**DELEGATED DECISION TO DETERMINE APPLICATIONS FOR
NON-MATERIAL AMENDMENTS**

Reference No: 2021/NM/91567/W

Site Address: 1, Rose Mount, Birkby, Huddersfield, HD2 2BU

Description: Non material amendment to previous permission
2020/90417 for erection of single storey extension

West Elevation_existing

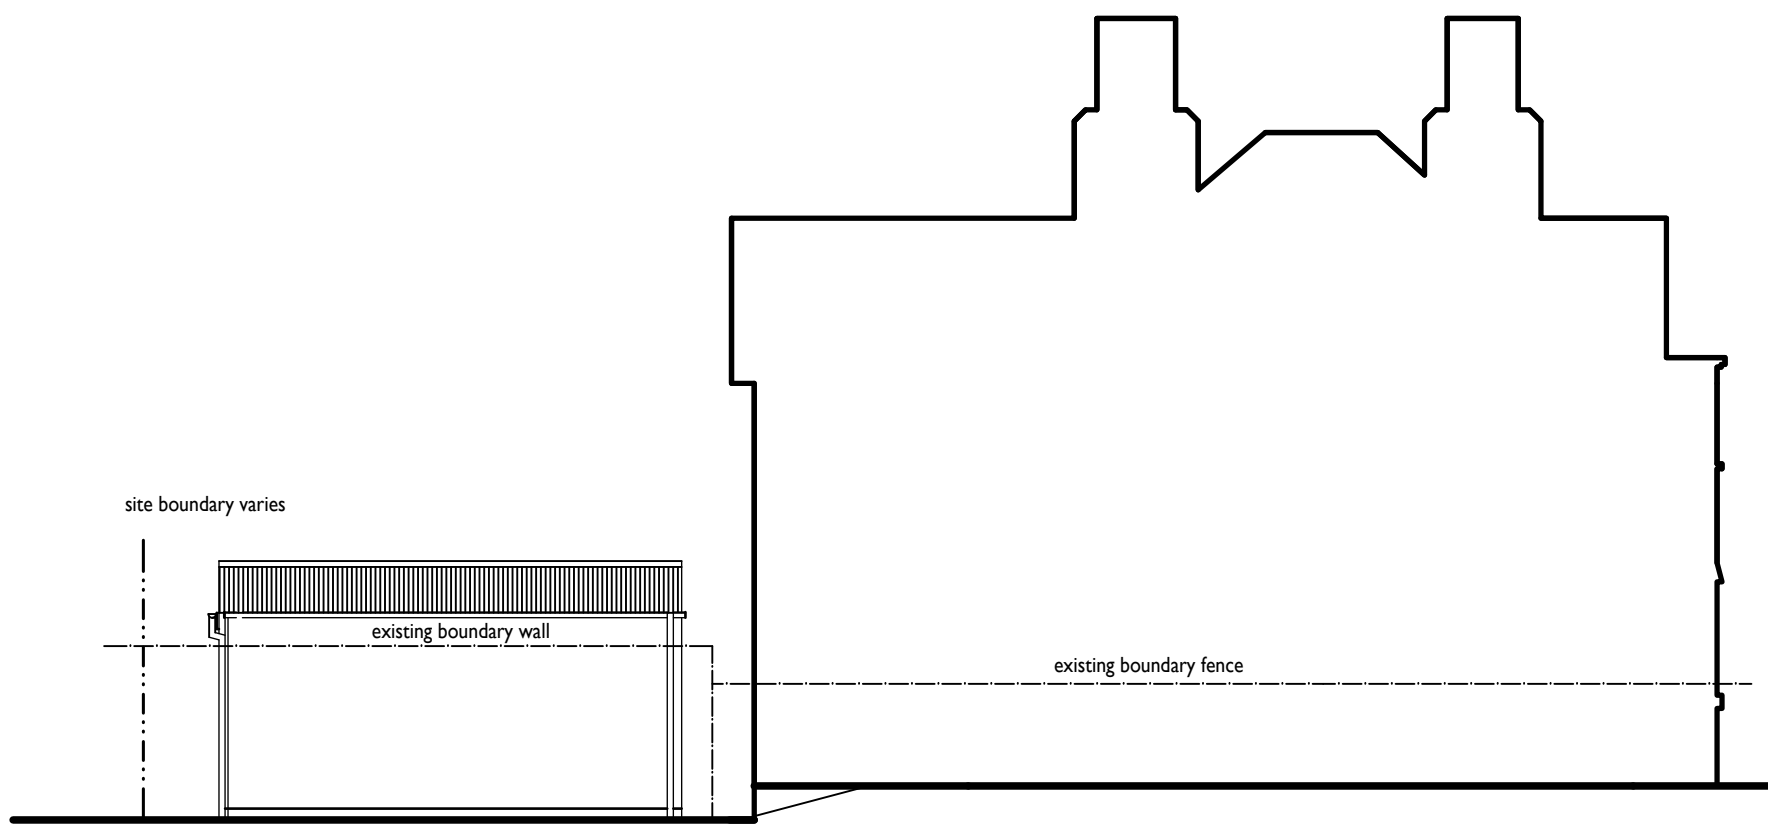
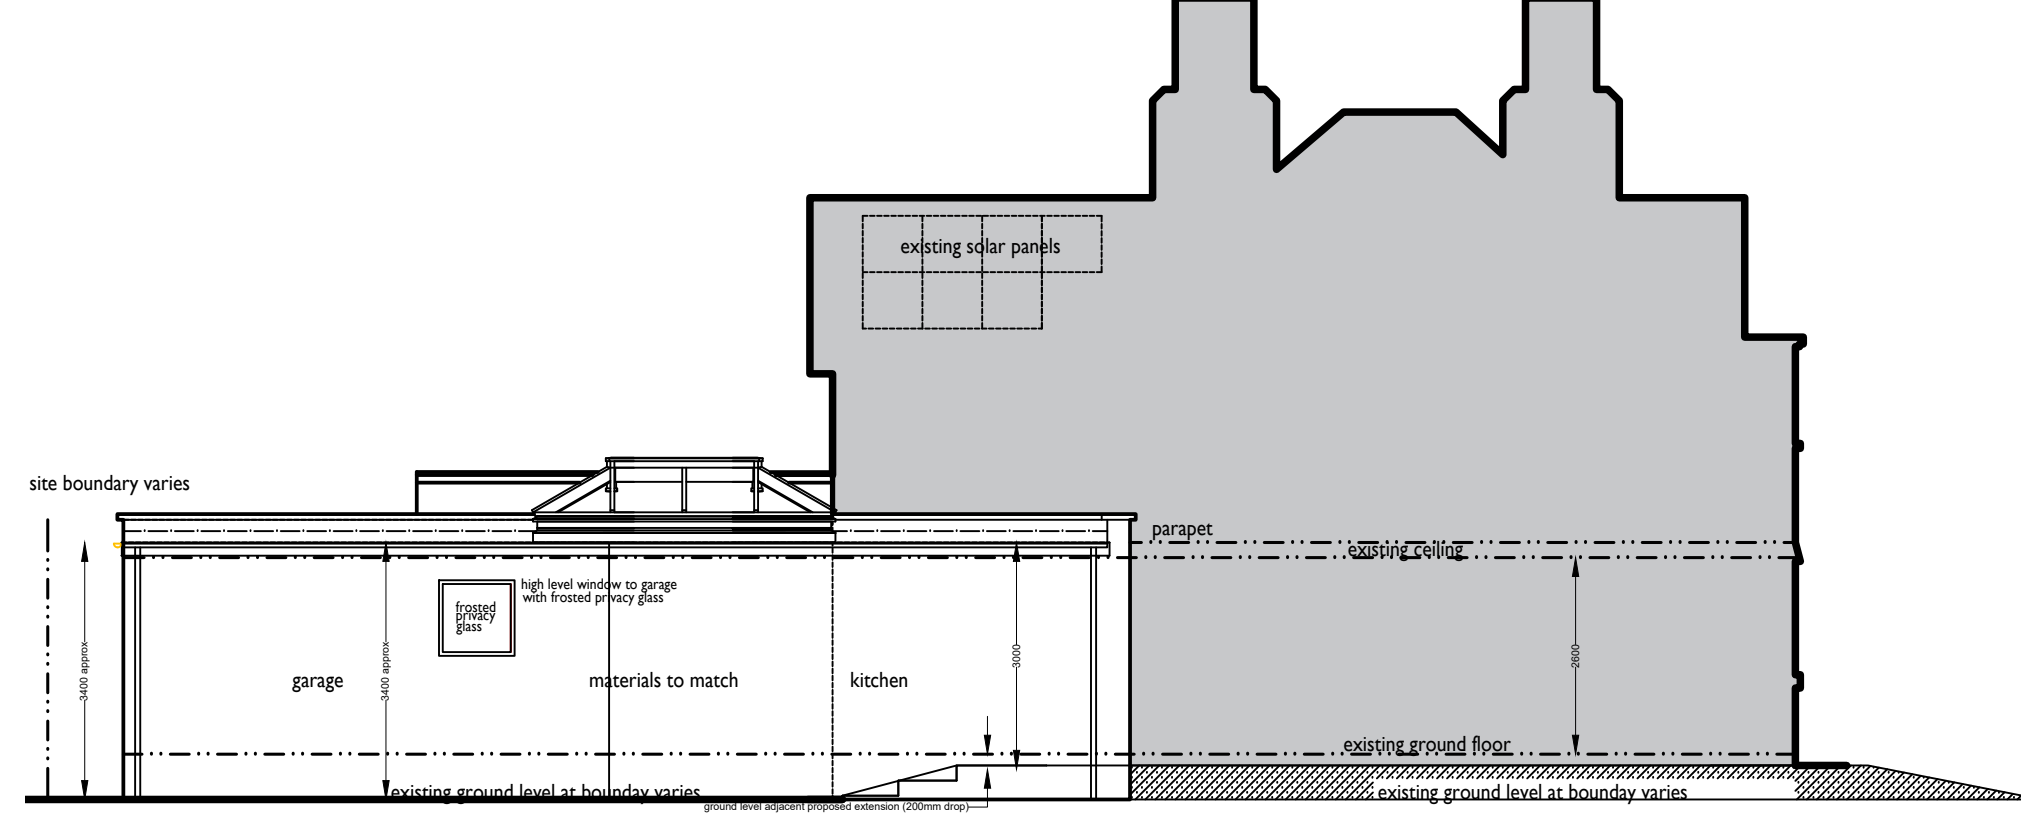
The amendment relates specifically to a longer roof lantern within the kitchen, a small set back to the rear wall of the garage and also a small pitch to the front of the garage roof.

- The proposed change must not contravene any condition attached to the original permission – **no condition would be contravened. It is noted that additional openings are shown within the side and rear elevations of the garage however there is a condition removing permitted development rights for no new windows or doors. These elements are proposed, and will be considered, in the assessment of 2021/91594**

- The proposed change should not require a further restriction to make it acceptable – **no further restrictions would be required**
- The proposed change would not result in any material increase in height, scale, width or depth of a building - **there is an increase in height to the extension however this is minimal and not considered a material increase due to being to the front section of the garage**

The amendment sought is for a longer roof lantern within the kitchen, a small set back to the rear wall of the garage and also a small pitch to the front of the garage roof as shown on drawing numbers Revision 01 Existing and Proposed Elevations and Revision 01 Existing and proposed Floor Plans.

Note: This permission does not extend to the additional window openings within the side and rear elevations of the garage.
